**COLORADO**  
**Department of Transportation**  
Region 2  
Traffic & Safety - Access Permits

RE: Mayberry Sketch Plan - SKP236

RE: Mayberry - Sketch Plan\_SKP236

The Traffic Impact Study for Mayberry Filing No. 5\_Sketch Plan-SKP236, dated August 30, 2023 by HDR Engineering, Inc. has been reviewed by a CDOT Traffic Engineer. Their comments follow:

**Table 3: Summary of Pass-by and Internally Captured Adjusted Daily and Peak Hour Trip Generation for the Mayberry Sketch Plan**

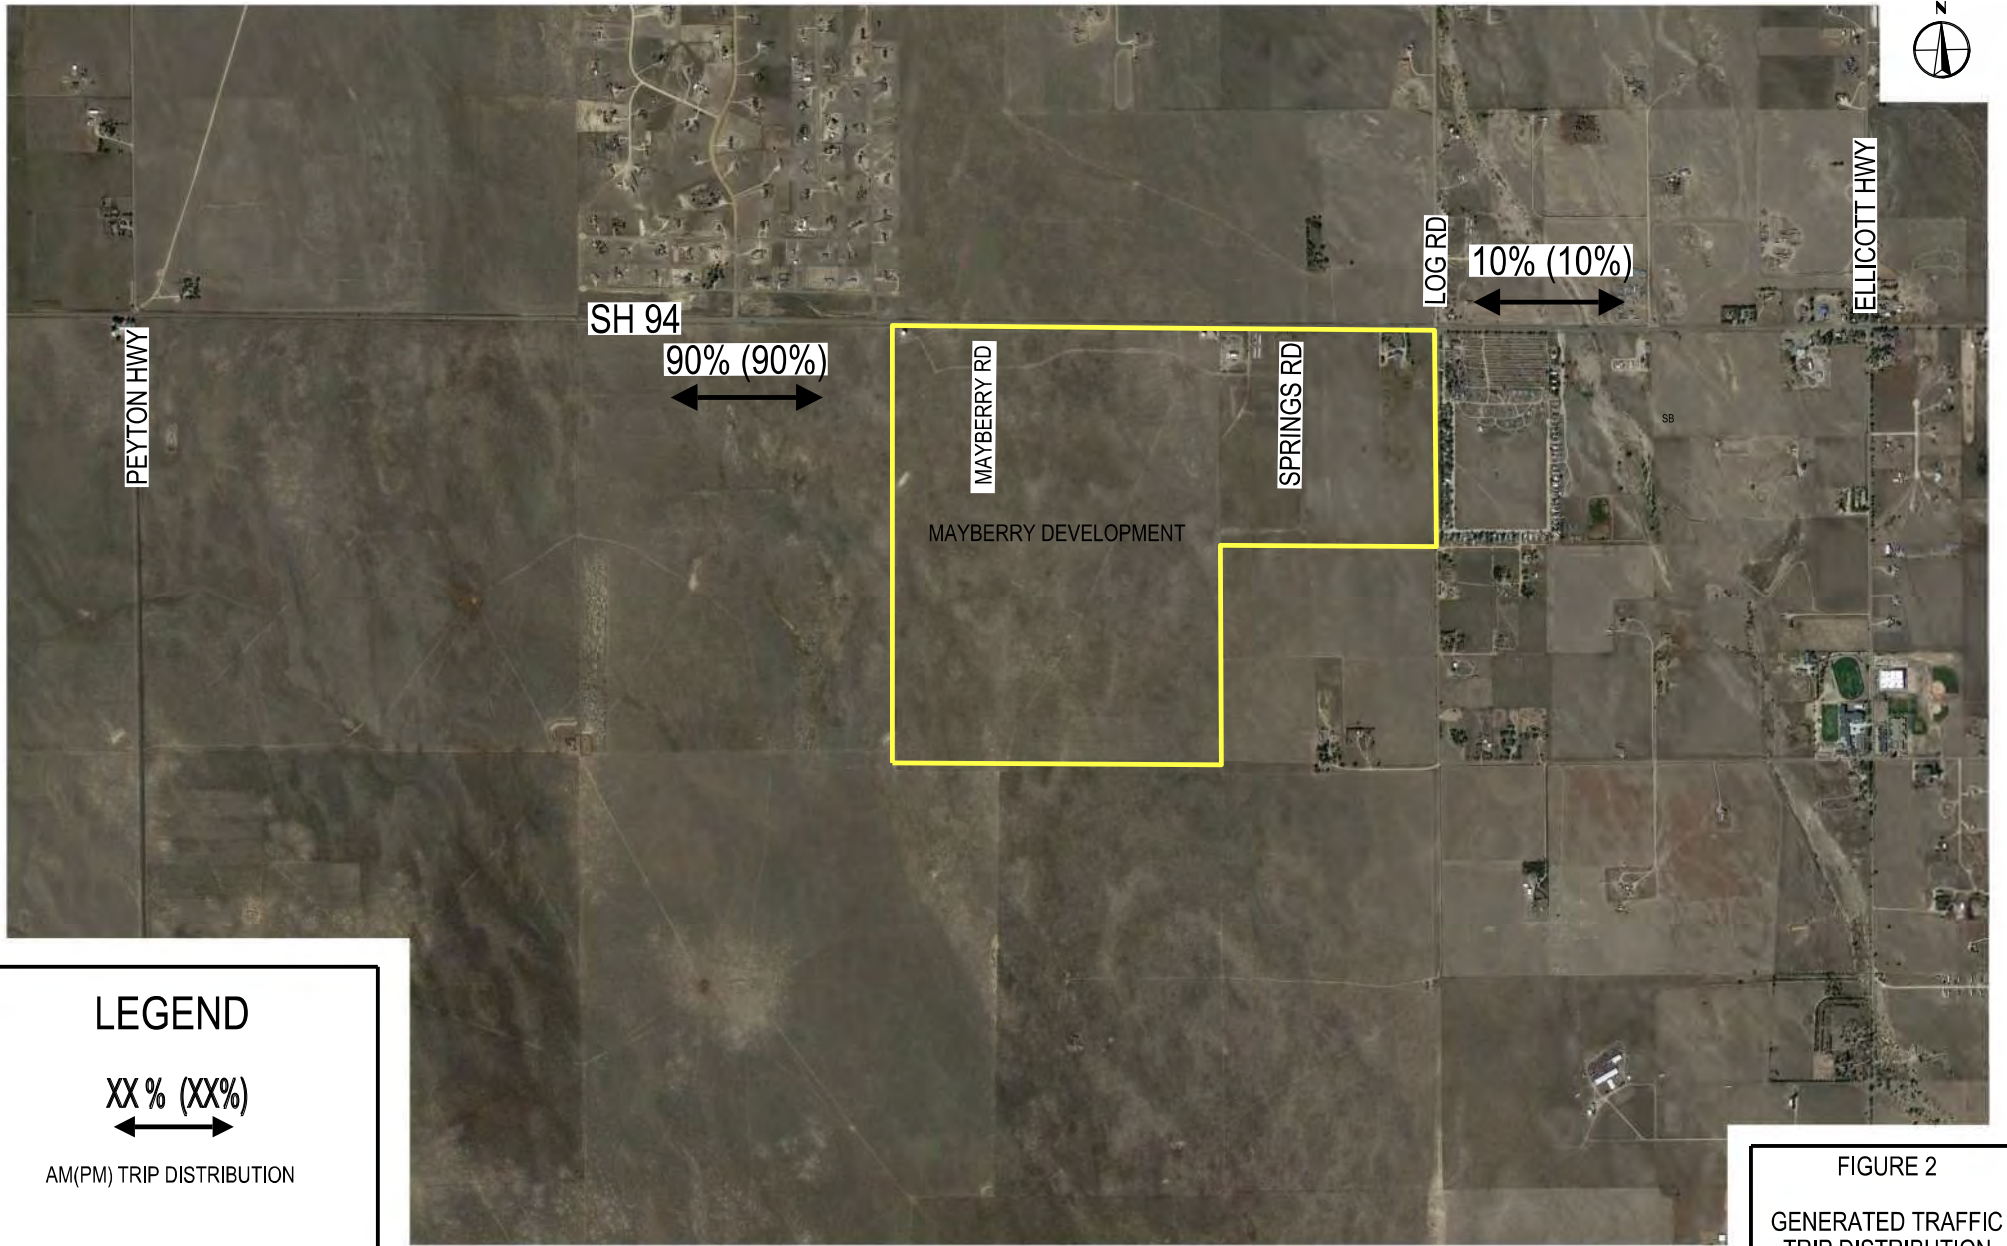
- This TIS serves as an update to previously approved studies for Ellicott Town Center and Mayberry. The site is anticipated to generate 38,497 vehicle trips over the life of development. Trip generation tables use “DU” for commercial uses such as a liquor store, fast casual restaurant, sit down restaurant and gas station. Seems as though the trip should be calculated on KSF, please modify and update. Also, KSF is used for Single Family Attached Housing when it should be DU.
